Our ref: RA/2020/142134/02-L01
Your ref: 2020/91292
Date: 26 November 2020

**ERECTION OF RETAIL KIOSK – BATLEY SHOPPING CENTRE, ALFREDS WAY,
BATLEY, WF17 5DR**

Proposed floor layout

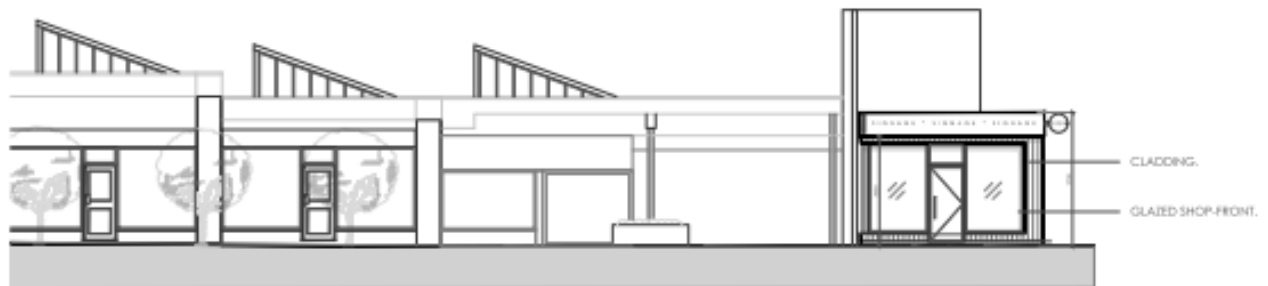
Our previous objection was because the kiosk was too close to Batley Beck. The revised drawing 'Proposed Plans A(SK)-05, revision B', dated 2/11/20 by Cole Gornall Cross Architects, now shows the kiosk to be located 3 metres from the dry side of the wall at the top of the bank adjacent to Batley Beck. We are therefore able to remove our objection, but ask the LPA to ensure that this revised drawing is included in the list of approved plans on the decision notice if permission is granted.

We require a minimum 3 metre easement for any works from the bank of Batley Beck to allow us access for maintenance purposes and any future works we plan in the area.
